From: Darren Edmonds [REDACTED]
Sent: 26 July 2017 14:41
To: Planning
Cc: mark gibbens
Subject: Further Information Required on Your Ref: PP-06219791 Our Ref: M/70/17/HH

-On the existing and proposed Location plans, please provide one named road - This has now been updated (see attached pack)

ELEVATION FACING WEST

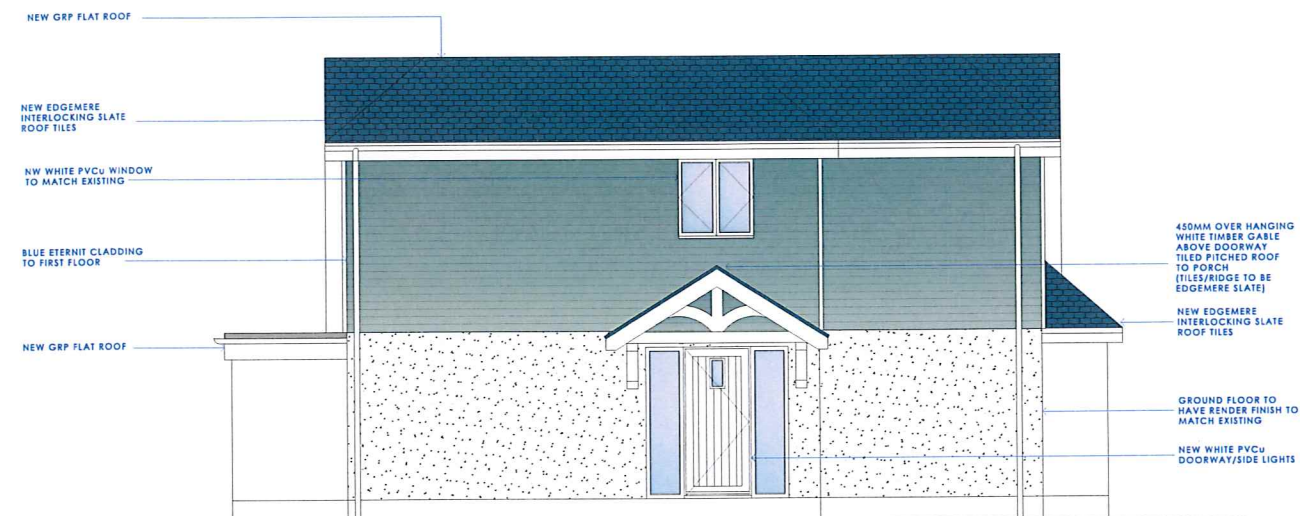
-Please confirm if you wish the new window on the ground floor West Elevation included in the description - Spoke to you on the phone with regards to this, not really sure what the issue is, West Facing Elevation shows a new door with two side windows the floor plans also illustrates this on the corresponding side - I have updated the description on both the elevation and floor plan to possibly aid this (see attached)

SITE BLOCK PLAN 1:500
OS TILE LICENSE NUMBER: 100022432

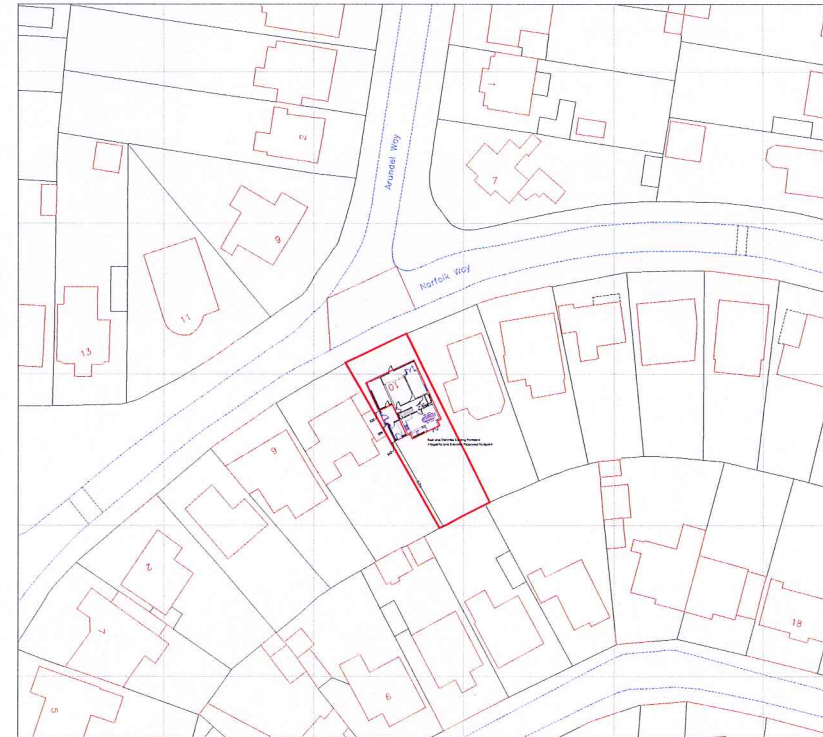
-On the proposed block plan, please highlight the proposed works and provide measurements from the proposal to the site boundaries - The plan has now been updated to show this (see attached)
